Munson RV, CS-18-001

Please accept the following comments from El Paso County Public Health for the commercial service zone change and RV Repair/Storage request referenced above:

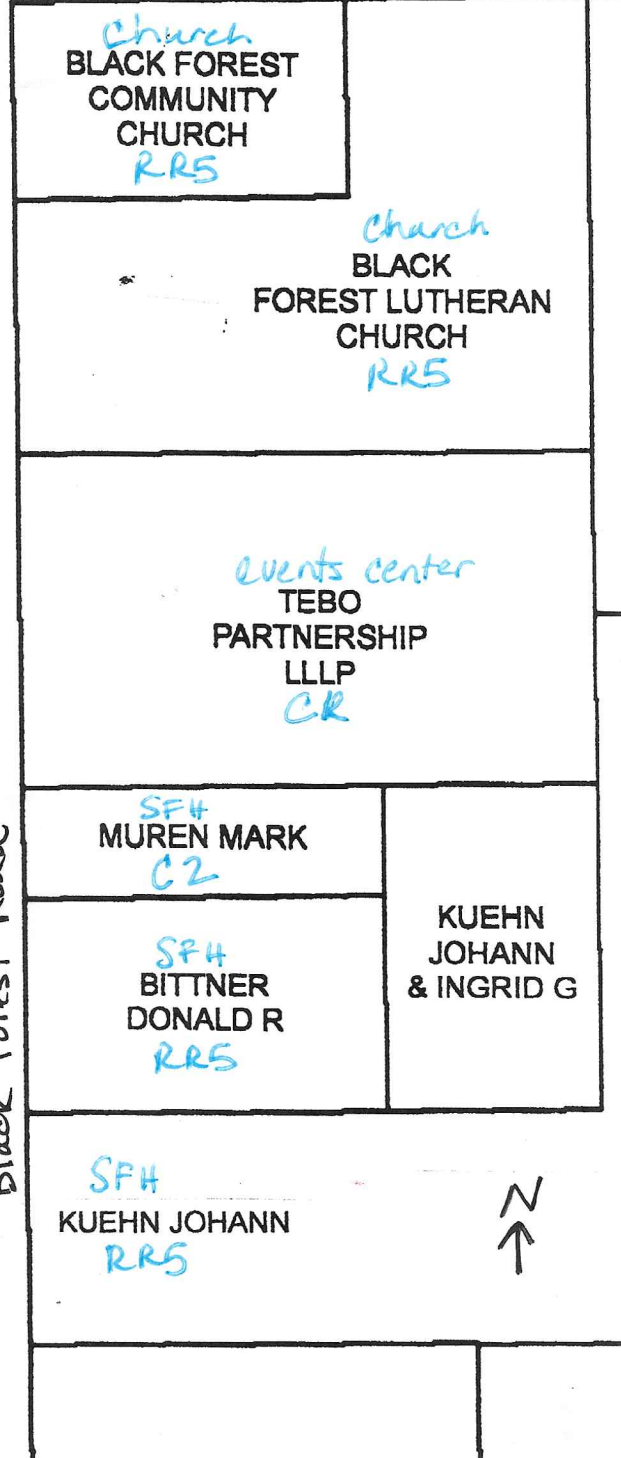
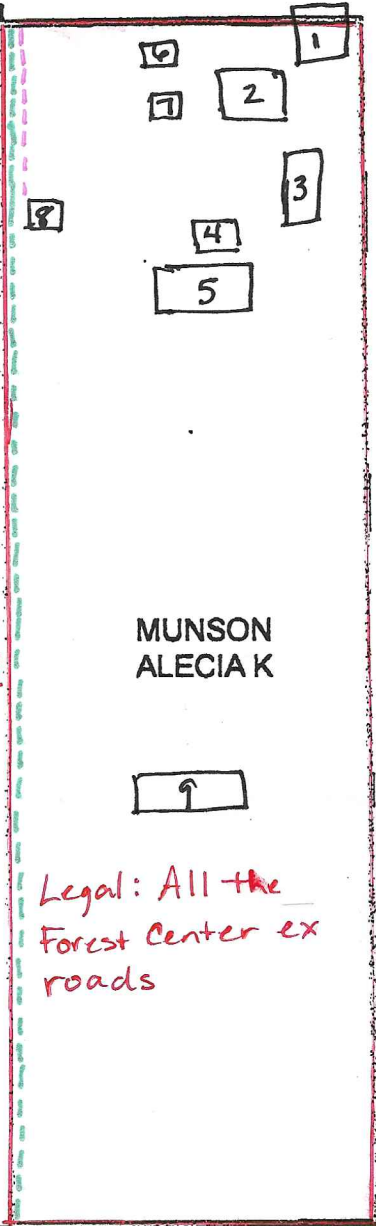
- **Wastewater service for the project is an existing on-site wastewater treatment system (OWTS). The existing OWTS must be evaluated by a Colorado Registered Professional Engineer to verify if it is adequately sized for the proposed change in operation.**

- **Precautions such as fencing or barrier-type perimeter around both the existing soil treatment area and the required area for a secondary site must be taken to protect the areas from compaction by vehicular traffic and parking. Compaction of the soil treatment area may lead to pre-mature failure of the soil treatment area.**
